Re: Site Plan Control Application – MVCA Comments
140 Reis Road

MVCA REVIEW COMMENT

KOLLAARD RESPONSE:

SITE GRADING PLAN
 SCALE = 1:1500

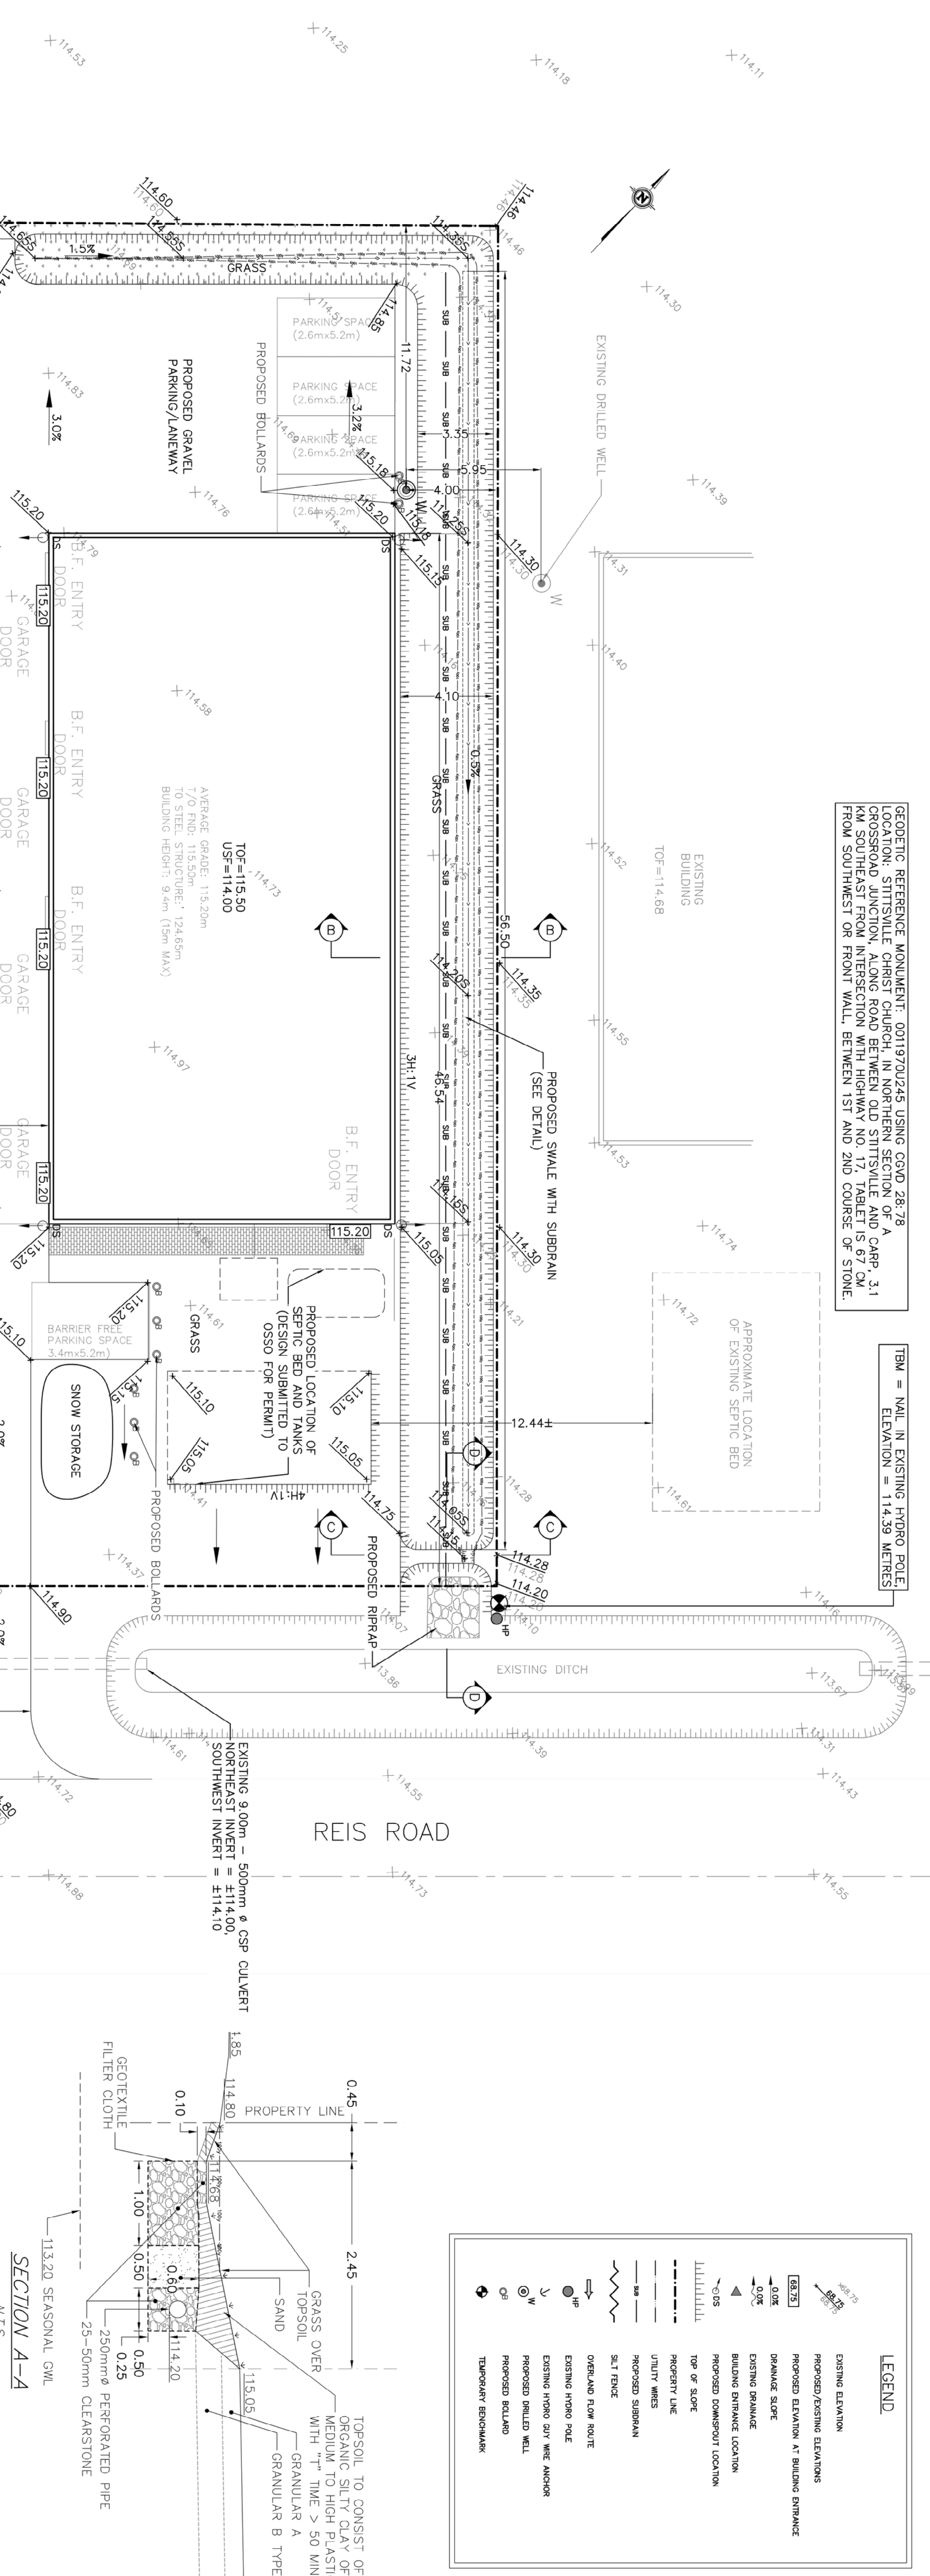
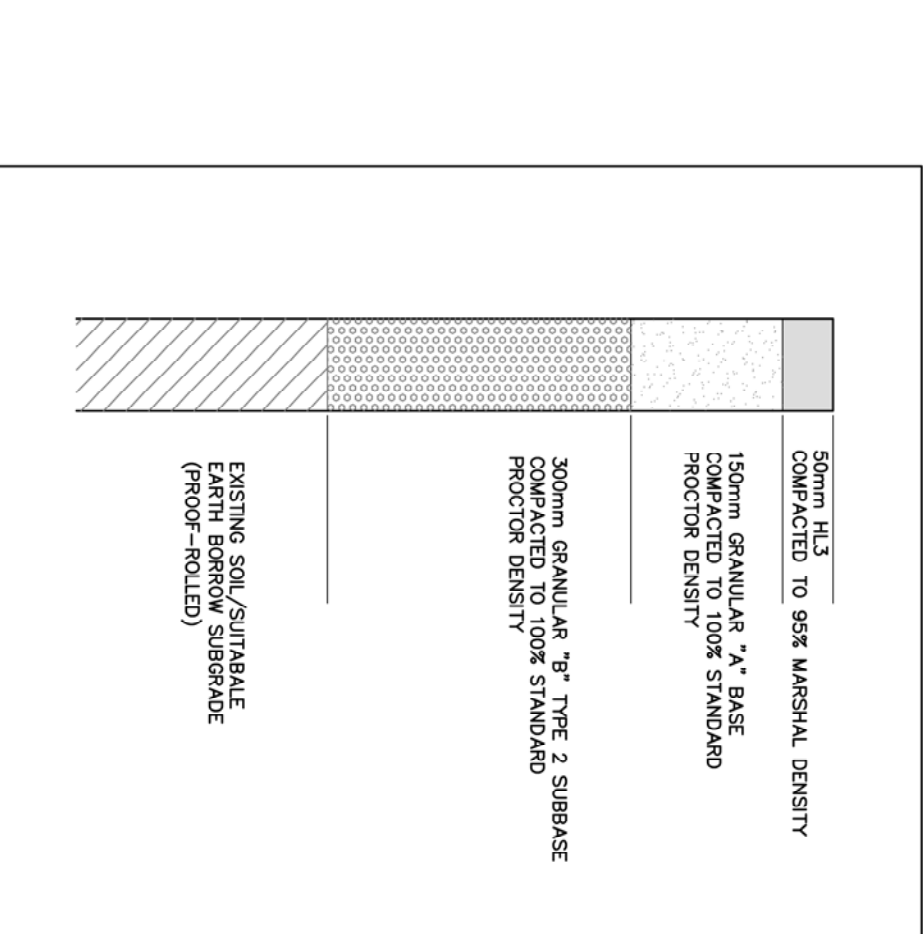
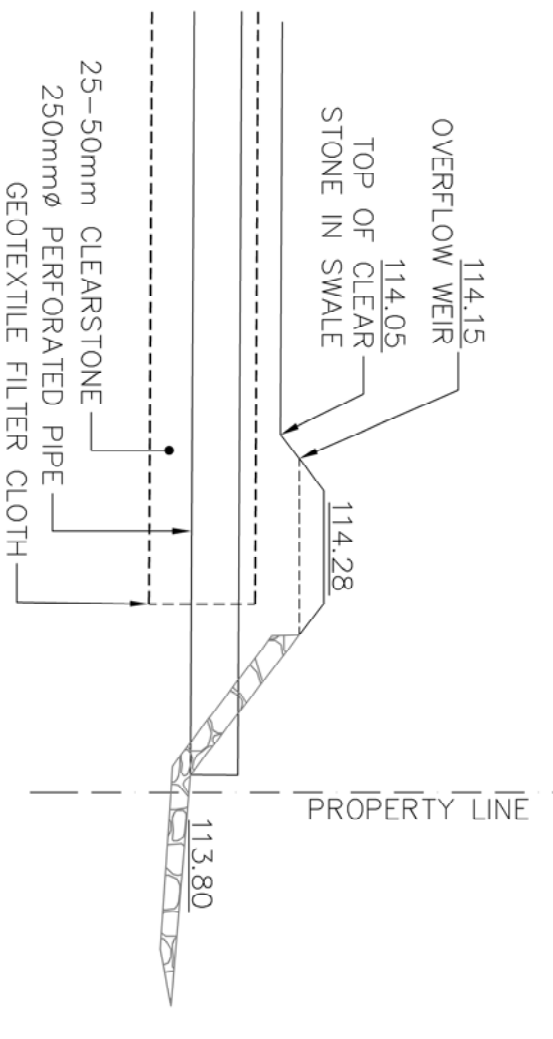
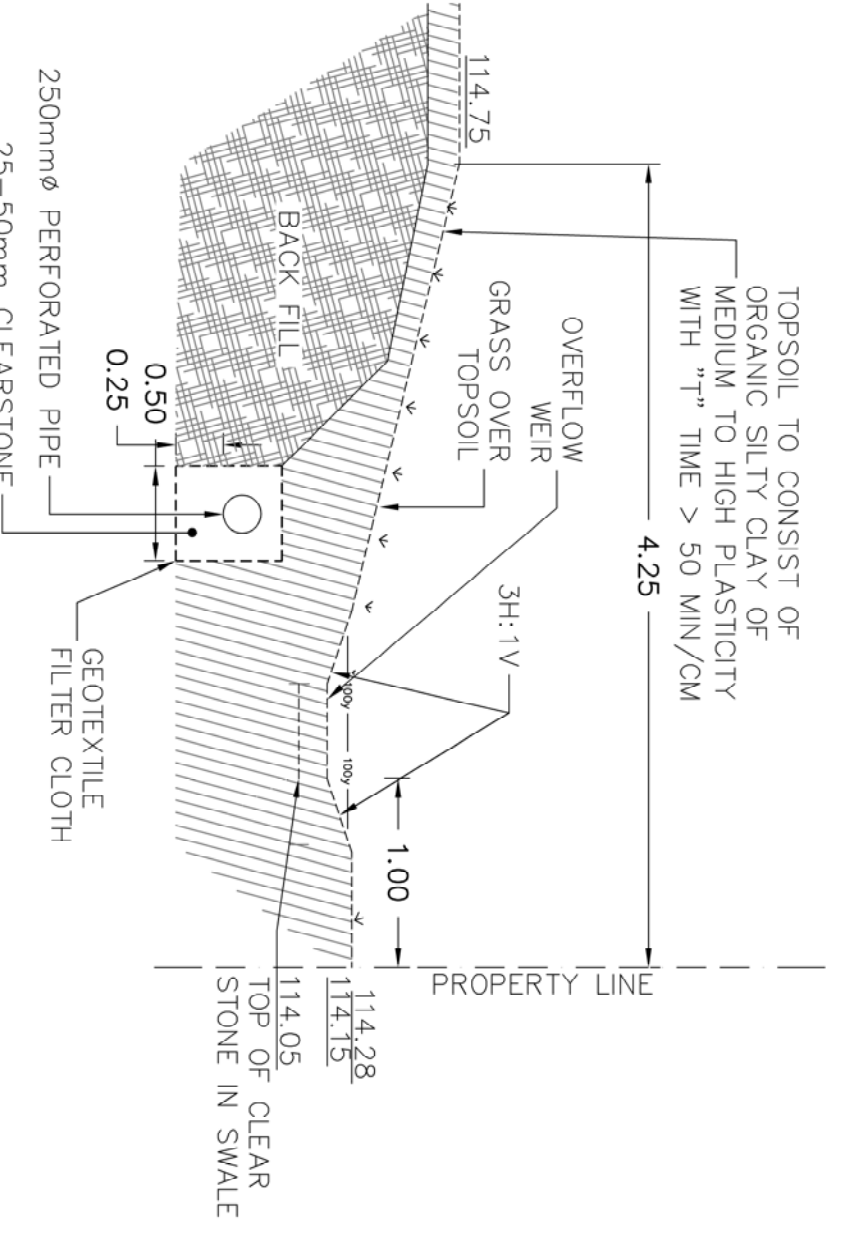
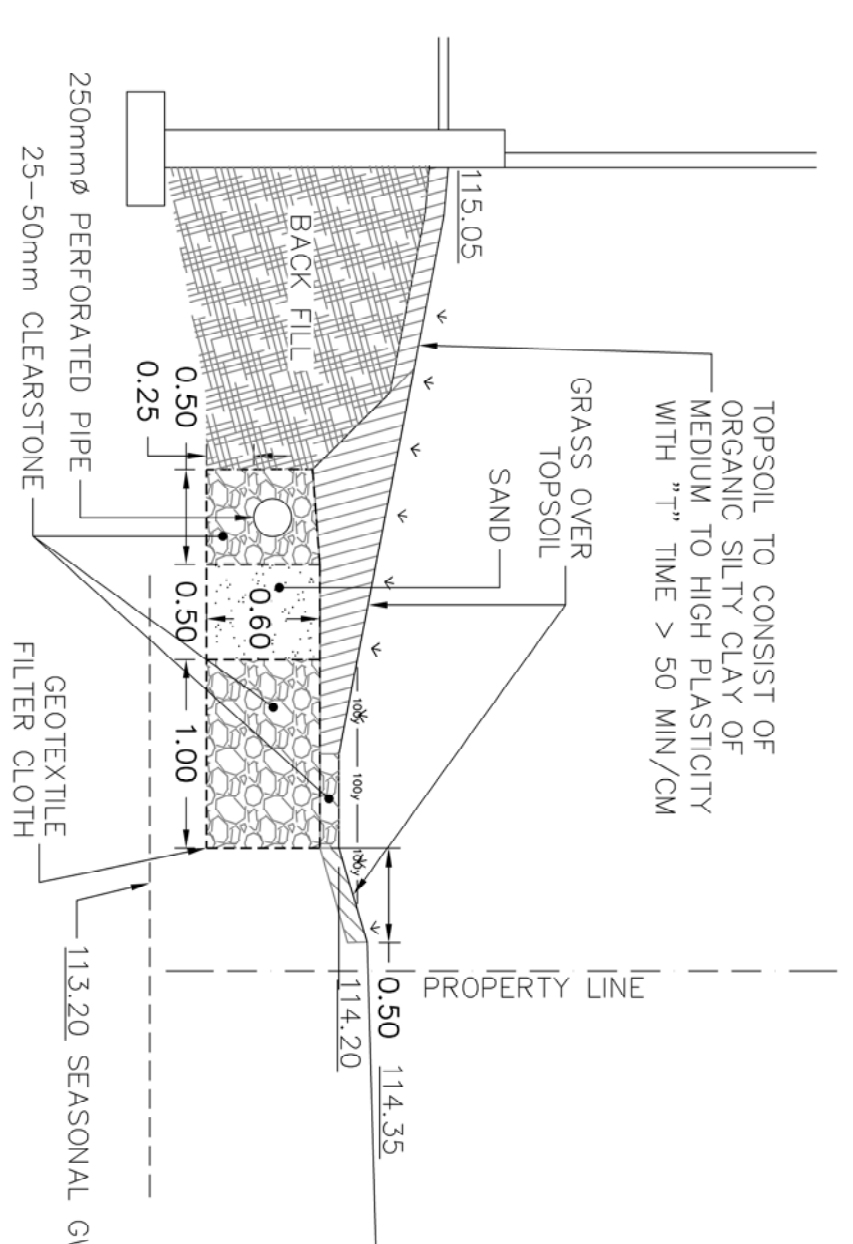
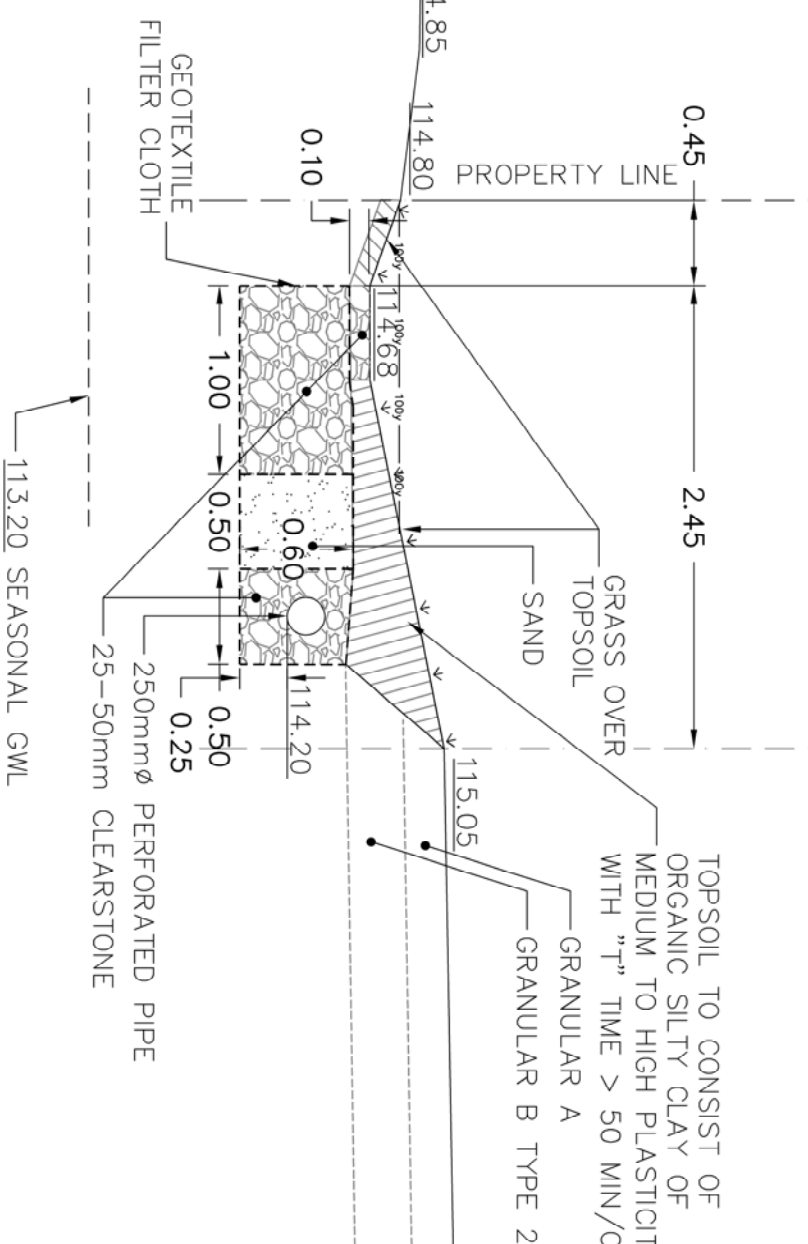
Most of our previous comments were addressed in the revised report. It is acknowledged that the west swale has a capacity issue. As per response comment #4, the actual flow depth of the west swale during a 100-year storm event will exceed the available depth (i.e., 11.3 cm – 10 cm = 1.3 cm), and this will cause the 100-year flow to extend 0.1 metres onto the neighbouring property. It is understood that on-site stormwater quantity control is not required. However, site alteration must not result in additional runoff being directed onto adjacent properties. Please revise to ensure that drainage is contained within the site. It would be beneficial to increase the depth of the swale and/or provide a proper maintenance plan to ensure that the swales will function as designed for the 100-year storm

Kollaard has revised the proposed west swale design notwithstanding the calculations (provided on the following page) that demonstrate that the flooding of the west swale, as designed with a minimum depth of 0.1 metres, does not result in additional flow onto the adjacent property.

The bottom of the swale was lowered by 2 cm as required to increase the minimum available flow depth to 0.12 m which results in an increase in the minimum flow capacity within the swale. The 100 year flow will be completely contained on the subject property. The grading plan and storm sewer design sheet for the 100 year event have been revised accordingly. The Site Servicing and SWM report and the remaining civil drawings have not been revised.

The revised storm sewer design sheet indicates that there is an excess capacity of 4.78 L/s in the west swale. This excess capacity does not include the capacity of the subdrain. As such, the capability of the swale to convey the 100 year flow will be preserved even if the function of the underlying subdrain becomes compromised in any way.
